Subject: Planning application AW/272/19/HH

My husband and I live at 49 Westminster Drive and have just seen the planning application for number 51 Westminster Drive, the middle of our block of three houses.

No.	Revisions:	Date:
-----	------------	-------

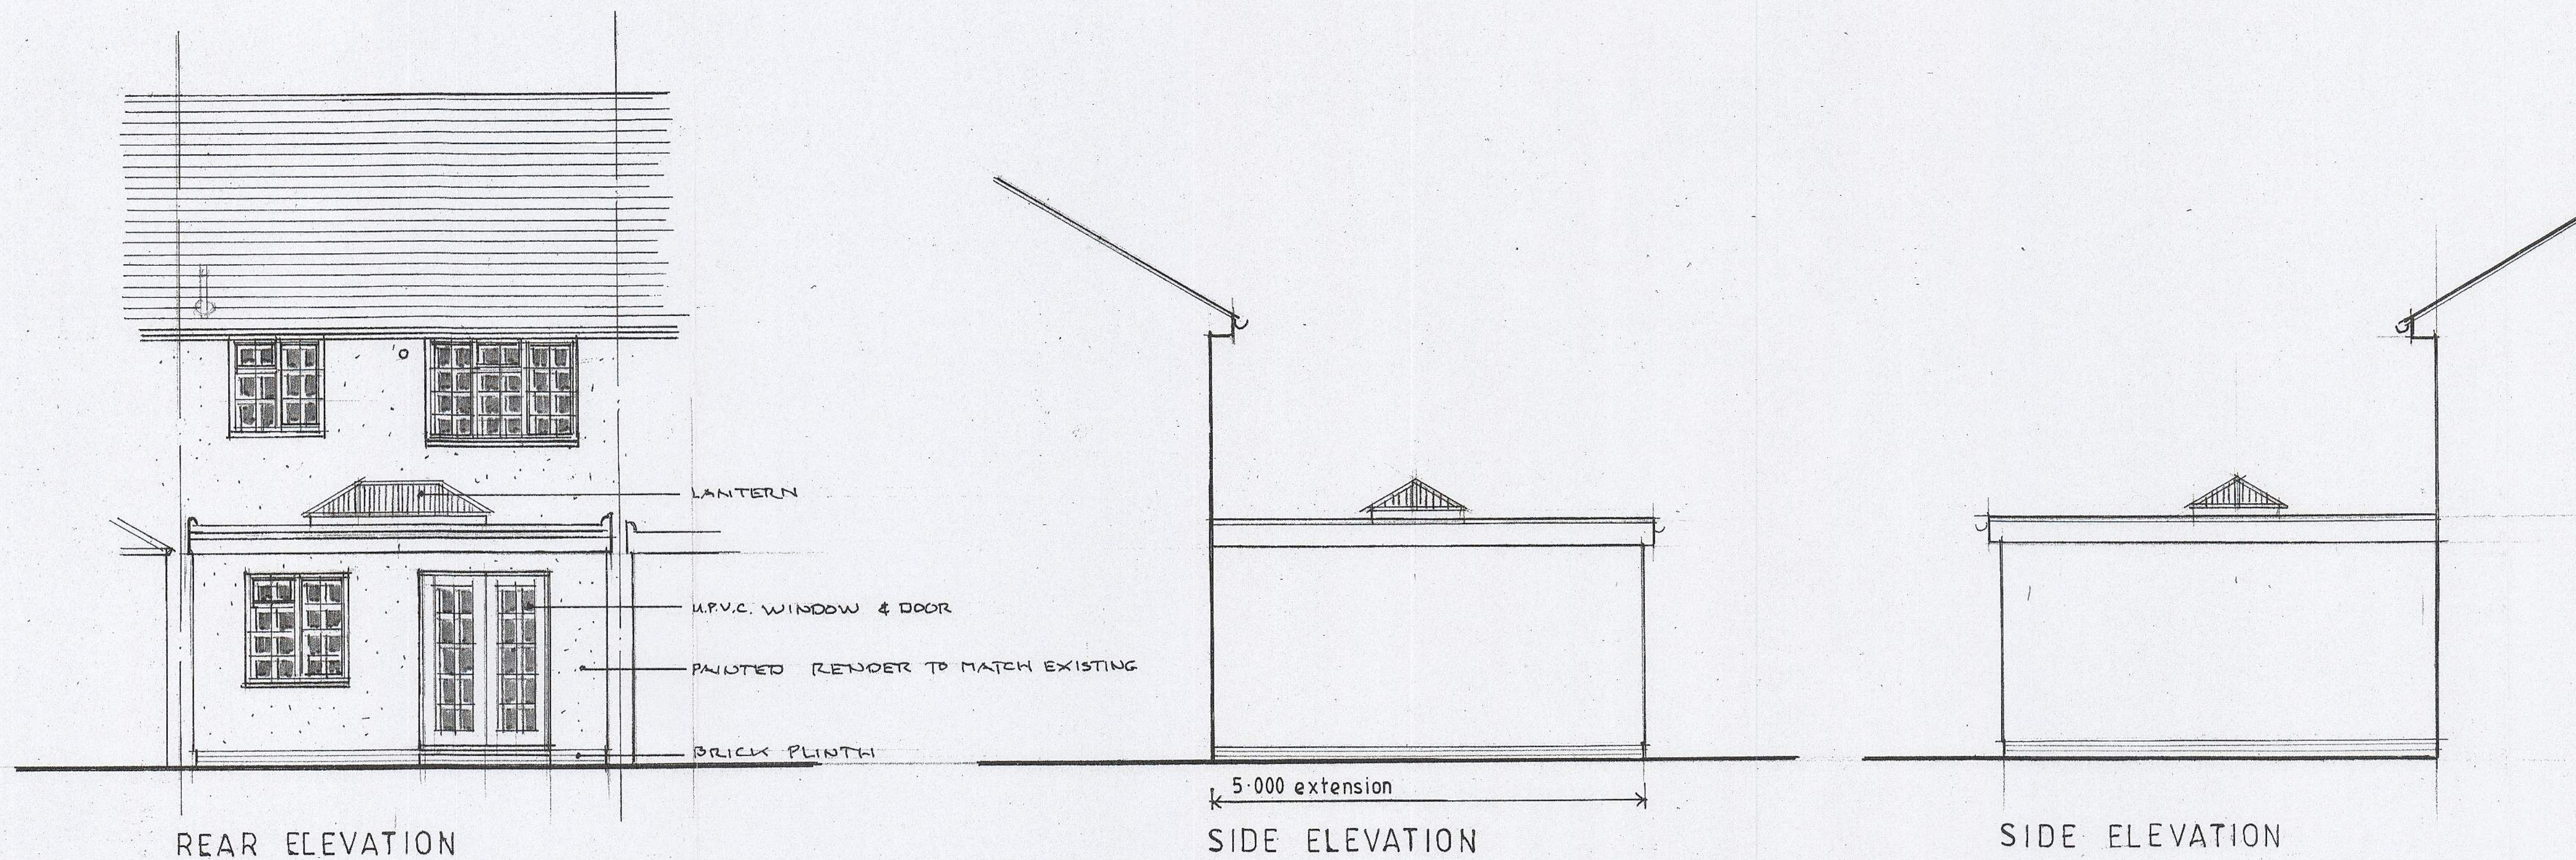
It has come to our attention that a previous owner of number 51 has slabbed over the foul water inspection cover serving our property. This cover is was just over the boundary line of our property and on to his.

There is a foul water drain for all three adjoined properties which runs under the ground about 2.5 metres out from the back walls of number 51 and 53.

We are worried therefore that the builders and architect will not be aware that a foul water drain with relevant inspection covers runs along the back of these two properties as there is no visual evidence of this.

I am also aware that due care and special measures need to be taken when building above a foul water drain run to protect the drain from collapse.

Whilst we have no objection to an extension we would like all necessary precautions to be taken and the foul water inspection cover to be re instated in an accessible position.
